CITY OF ALBUQUERQUE

October 30, 2015

**Re: Lincoln Complex, Building M Renovation
Drainage Report/Grading and Drainage Plan
Engineer's Stamp Date 10/19/2015 (K15/D047B)**

C-102R

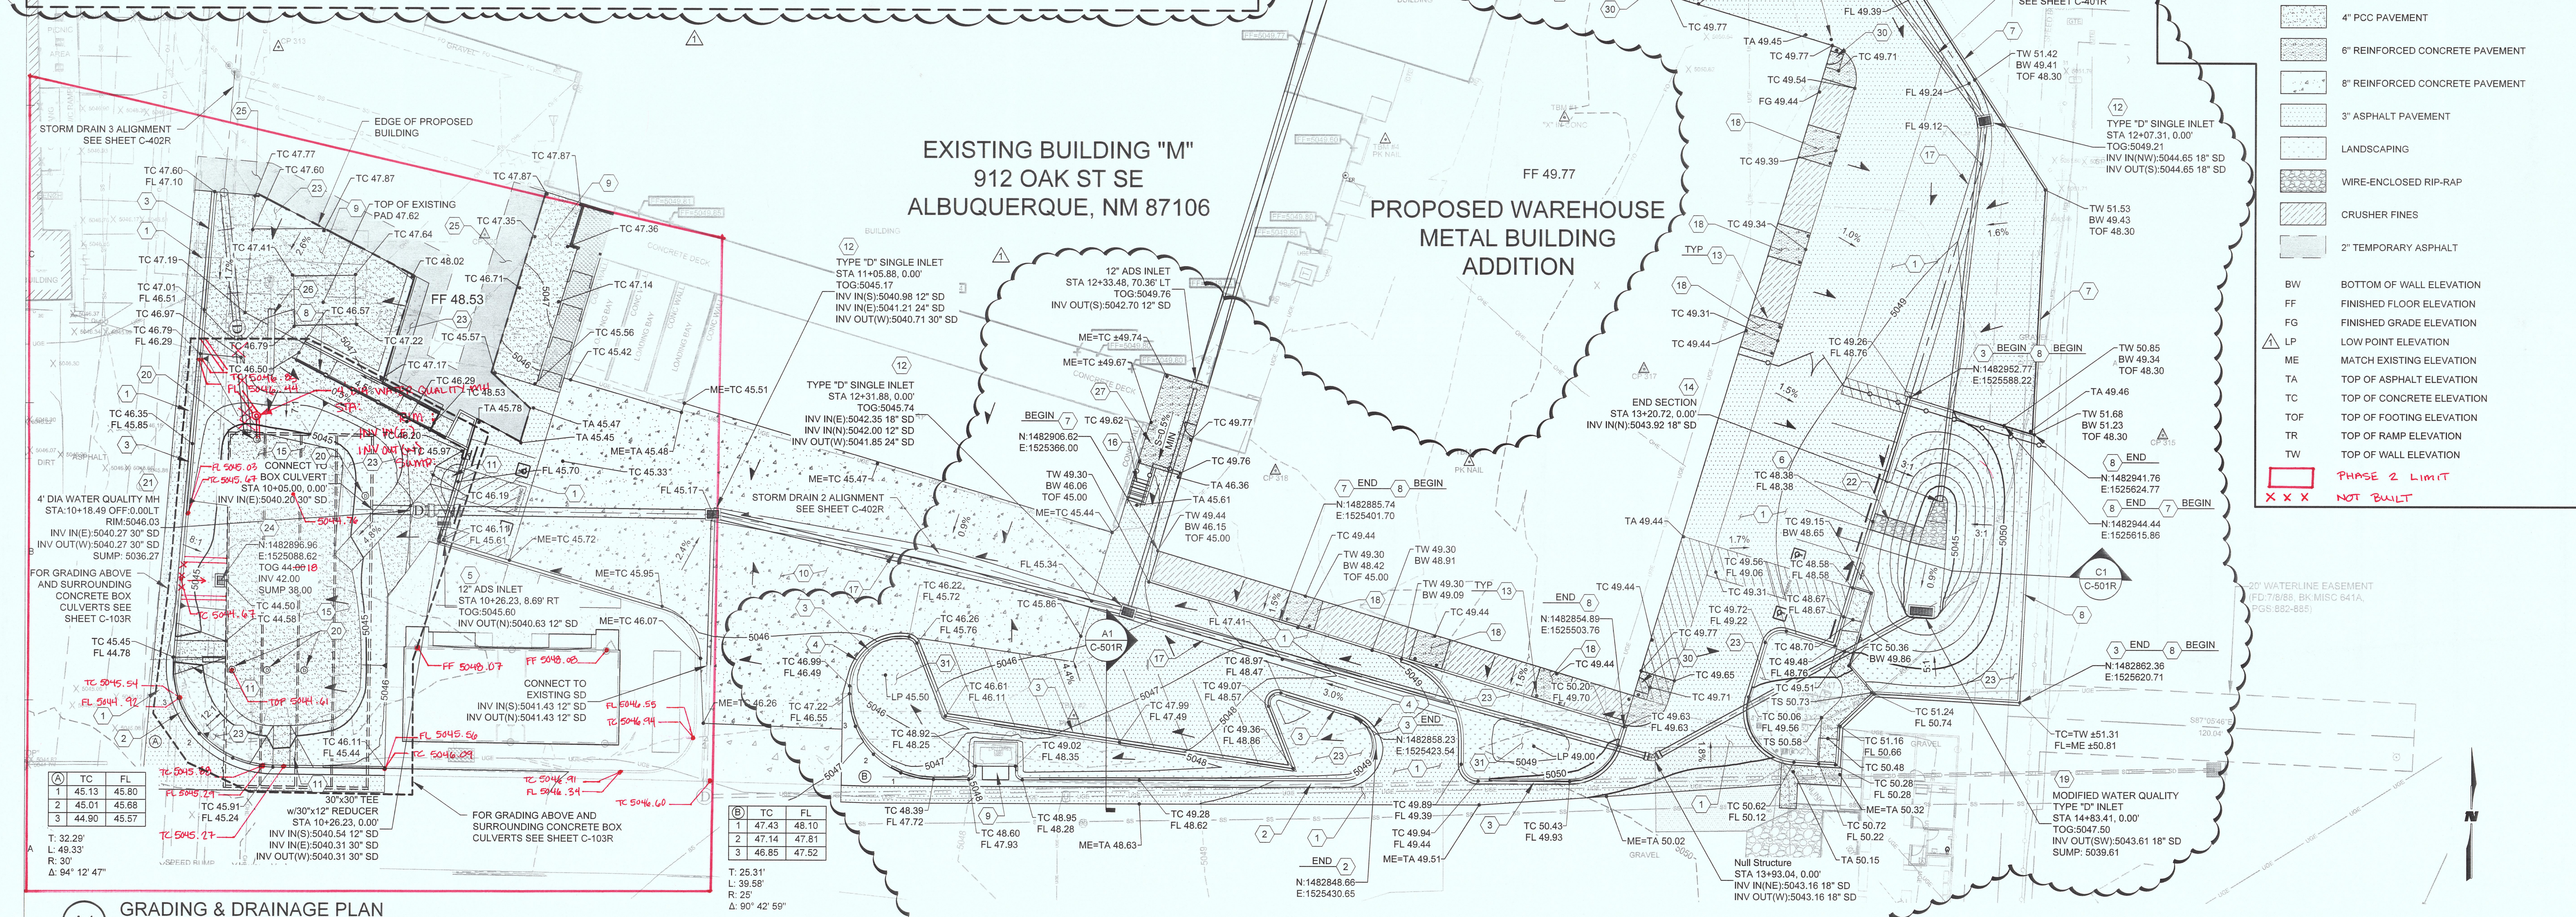
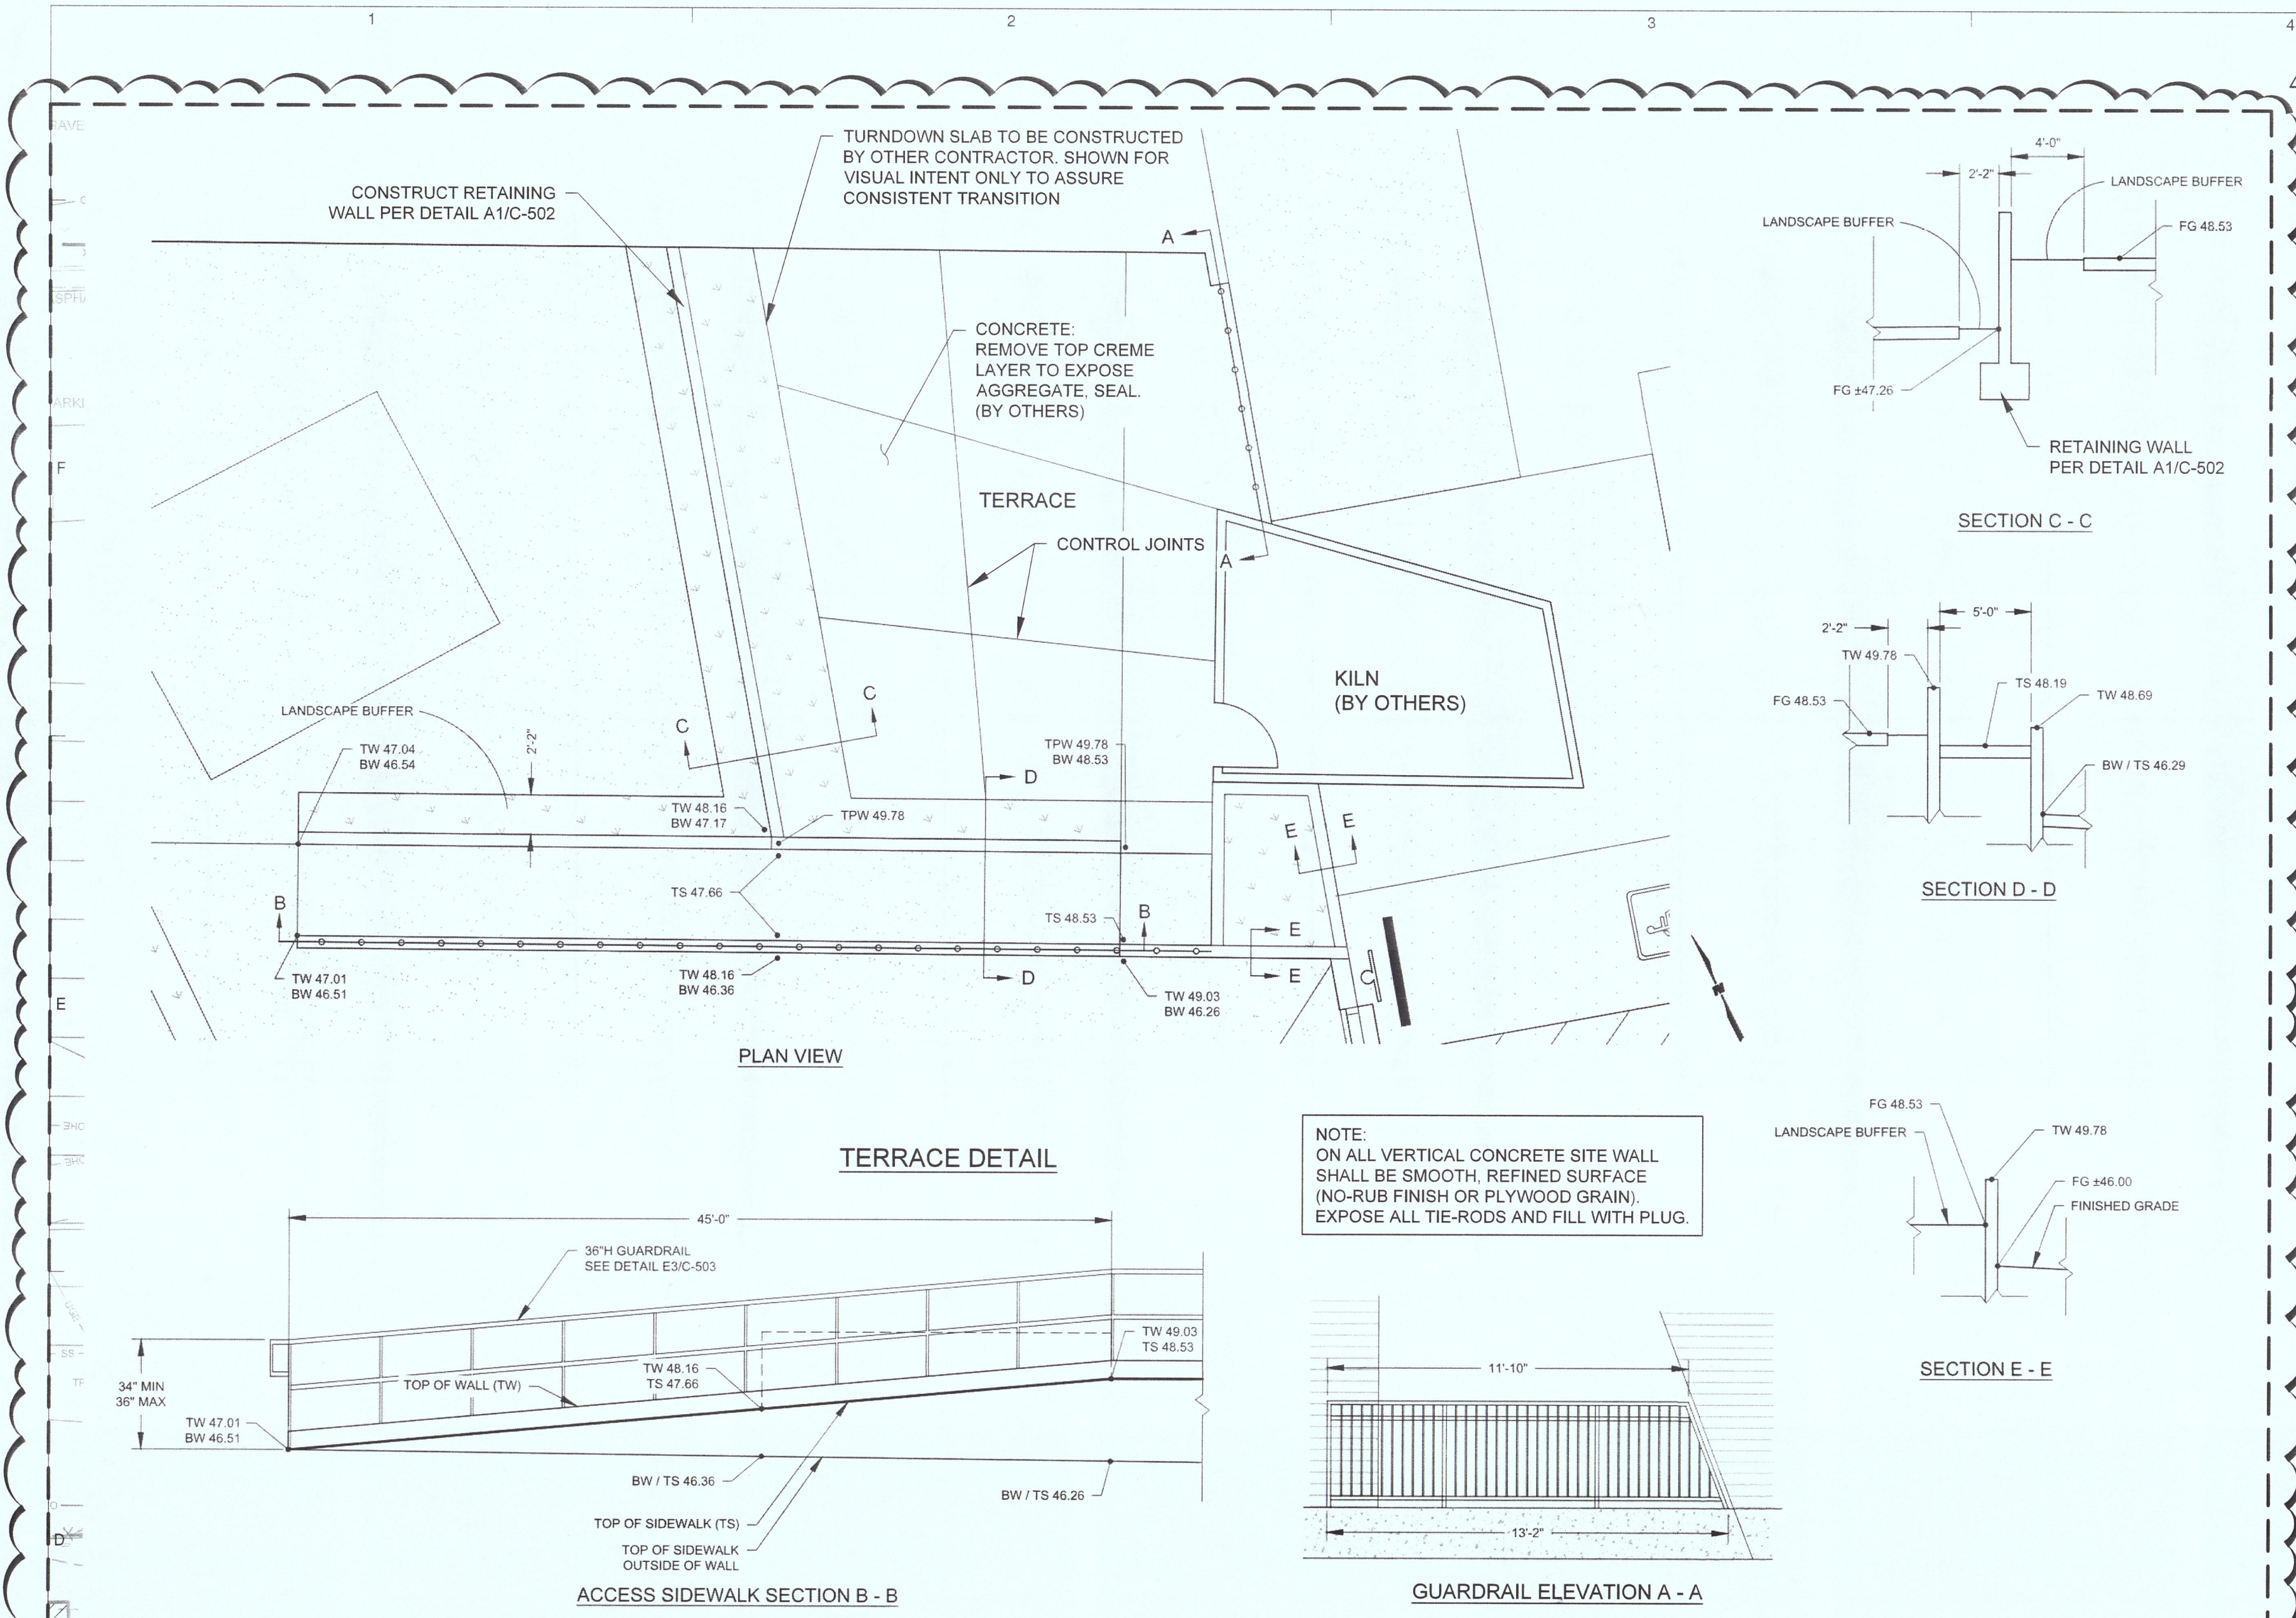
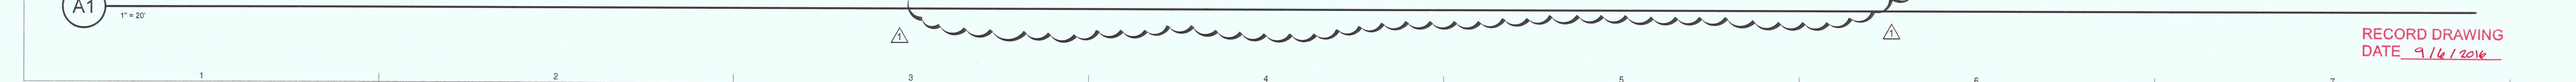
- The Grading and Drainage Plan (Sheet C-102) shows a 12" line that accepts flows from the roof drain for the Warehouse Metal Building (STA 12+35.16). This line is connected to the "Storm Drain 2" system, but it does not appear to be counted in the Hydraflow calculations/diagram.
- An exhibit that clearly shows the pipe numbers and inlets shown in Tables 5 & 6, and Page 10 of the Report is still not provided (Comment #3, Submittal dated 7-31-2015). At a minimum, the pipe and inlet numbers should be labeled in the Grading & Drainage Plans that are a part of the report.
